May 14, 2024  
Project #010014-01-217

**RE: F17D034 Chick-fil-A 5031 Montgomery Blvd**

Bowman Consulting is in receipt of your comment letters, regarding the above-mentioned Conceptual TCL for Chick-fil-A Montgomery Blvd. Please see the following response for further clarification as requested:

C-2.0

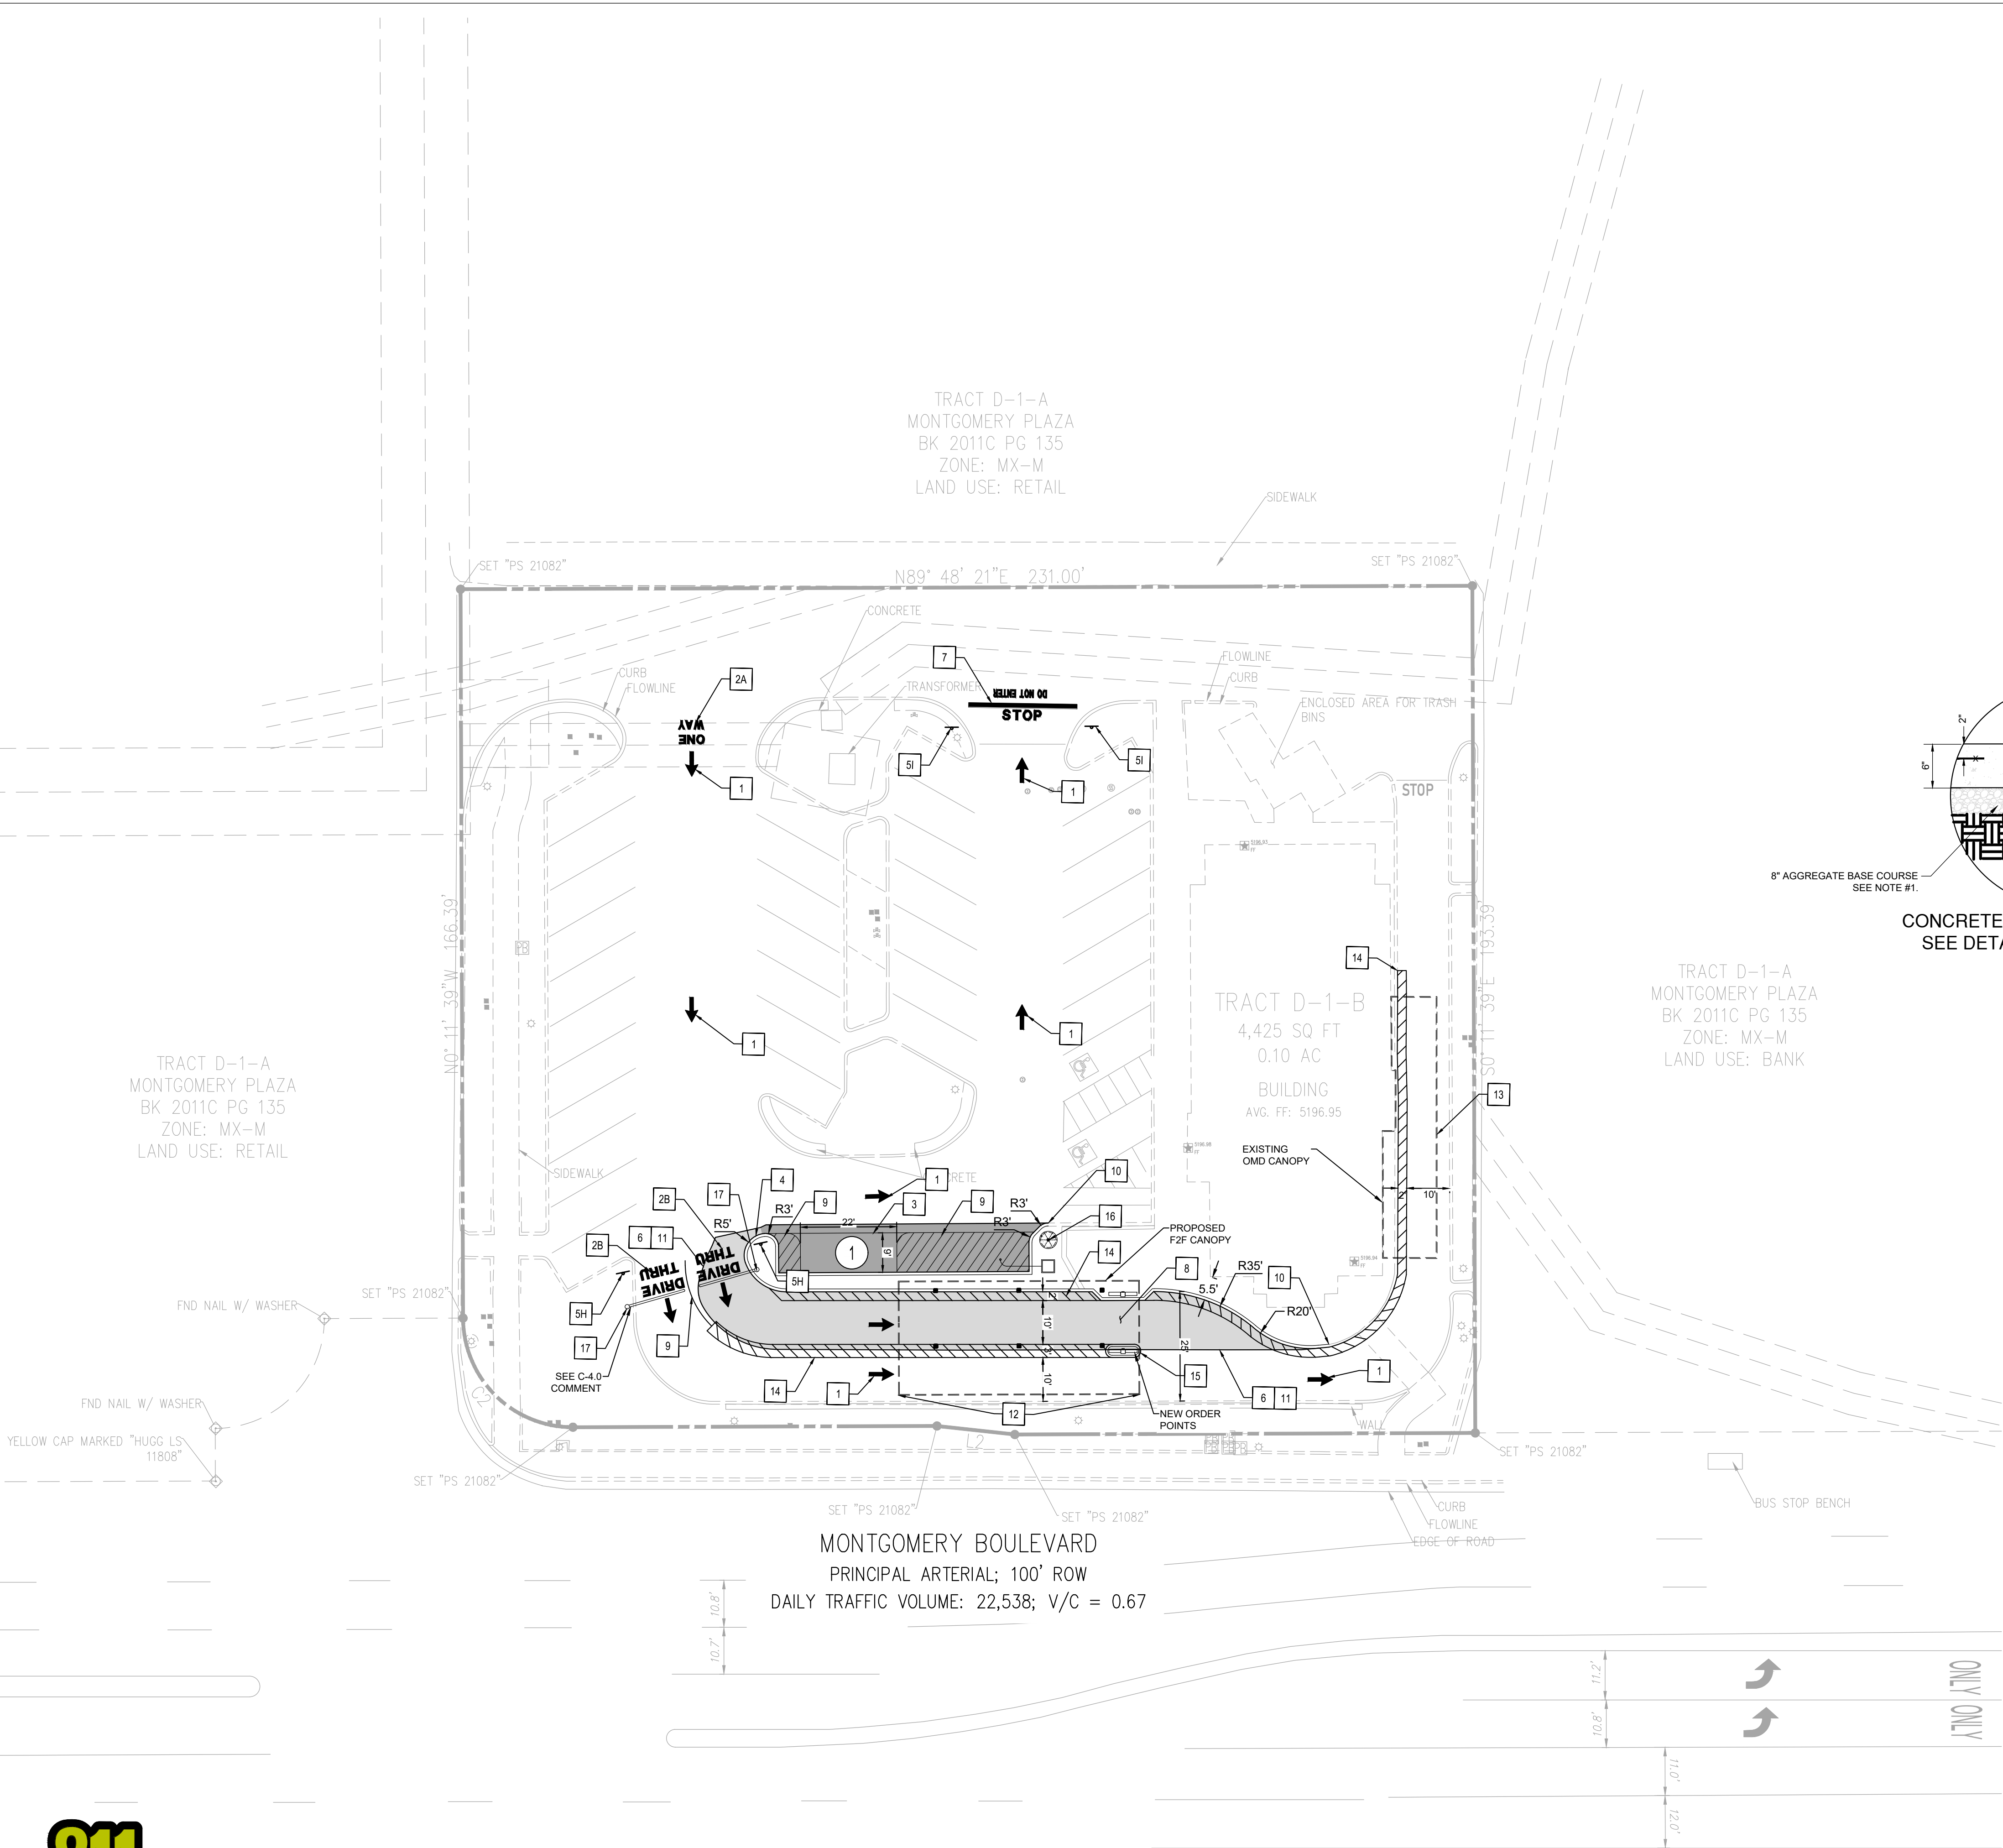
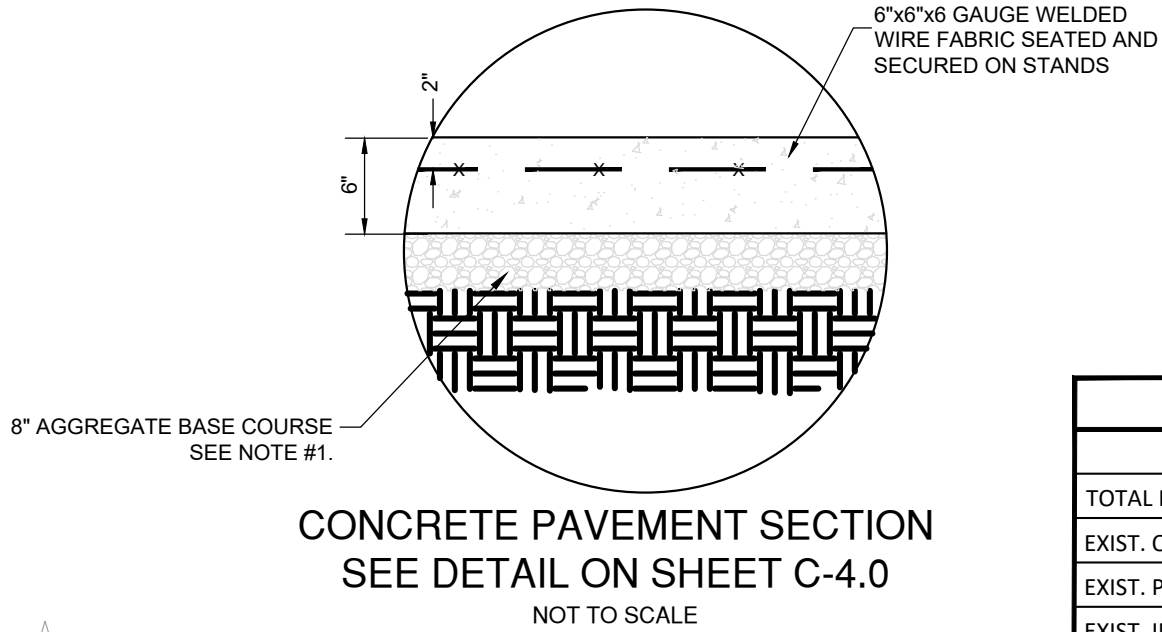
1. Please show a vicinity map on the site plan sheet C-2.0 showing the location of the development in relation to streets and well-known landmarks.  
**Response:** Vicinity map added to sheet C-2.0 – Site Plan.

2. List the number of Motorcycle and Bicycle parking spaces required by the IDO.  
**Response:** Number of motorcycle and bicycle parking spaces required shown in parking calculations table. Please see sheet C-2.0 – Site Plan.

3. Please show on the site plan, the required stacking spaces for the drive-thru lanes.  
**Response:** Required and provided stacking spaces shown in parking calculations table. See sheet C-2.0 – Site Plan.

4. Please list the degree, width and length for all existing parking spaces. Some dimensions are not shown. See attached Angled Parking dimensions requirements for reference.

6. The ADA accessible parking sign must have the required language per 66-7-352.4C NMSA 1978 **"Violators Are Subject to a Fine and/or Towing."** Please call out detail and location of signs.

**Response:** Detail added to sheet C-4.0 – CFA Standard Details and signs called out on sheet C-2.0 – Site Plan.
7. The ADA access aisles shall have the words **"NO PARKING"** in capital letters, each of which shall be at least one foot high and at least two inches wide, placed at the rear of the parking space so as to be close to where an adjacent vehicle's rear tire would be placed. (66-1-4.1. B NMSA 1978)

8. Please provide all the existing ADA ramps details (width, running and cross slopes). ADA curb ramps must be updated to current standards and have truncated domes installed.

9. The pavement marking "MC" should be shown in the opposite direction for motorcycles entering the parking space.

10. All bicycle racks shall be designed according to the following guidelines:

11. Bicycle racks shall be sturdy and anchored to a concrete pad.

12. A 1-foot clear zone around the bicycle parking stall shall be provided.

13. Bicycle parking spaces shall be at least 6 feet long and 2 feet wide.

14. Please show on the site plan these dimensions.

15. The minimum drive through lane width is 12 feet with a 25-foot minimum radius (inside edge) for all turns. (A 15-foot radius can be used with an increase in lane width to 14 feet). Please dimension all lane widths and radii.

16. Add a note stating, "All broken or cracked sidewalk must be replaced with sidewalk and curb & gutter." A build note must be provided referring to the appropriate City Standard drawing.

**Response:** Existing parking spaces dimensioned. Please see sheet C-2.0 – Site Plan.
5. Show on the site plan the existing drive aisles width.  
**Response:** Drive aisle width dimensions shown. Please see sheet C-2.0 – Site Plan.

**Response:** "NO PARKING" pavement markings added. Please see sheet C-2.0 – Site Plan.

**Response:** Existing truncated domes and ramp widths shown on sheet C-2.0 – Site Plan. Running and cross slopes are shown on sheet C-3.0 – Grading Plan.

**Response:** "MC" pavement marking added. Please see sheet C-2.0 – Site Plan.

**Response:** Bicycle racks added to plans. Please see sheet C-2.0 – Site Plan. Detail is on sheet C-5.0 – Construction Details.

**Response:** Bicycle racks anchored to concrete pad. See detail on sheet C-5.0 – Construction Details.

**Response:** Bicycle parking area has at minimum 1-ft clear zone. See sheet C-2.0 – Site Plan.

**Response:** Bicycle spaces dimensioned. Please see sheet C-2.0 – Site Plan.

**Response:** Requested dimensions shown. Please see sheet C-2.0 – Site Plan.

**Response:** Drive-through radii have been updated to 25-ft. Please see sheet C-2.0 – Site Plan.

**Response:** Note added to sheet C-2.0 – Site Plan.
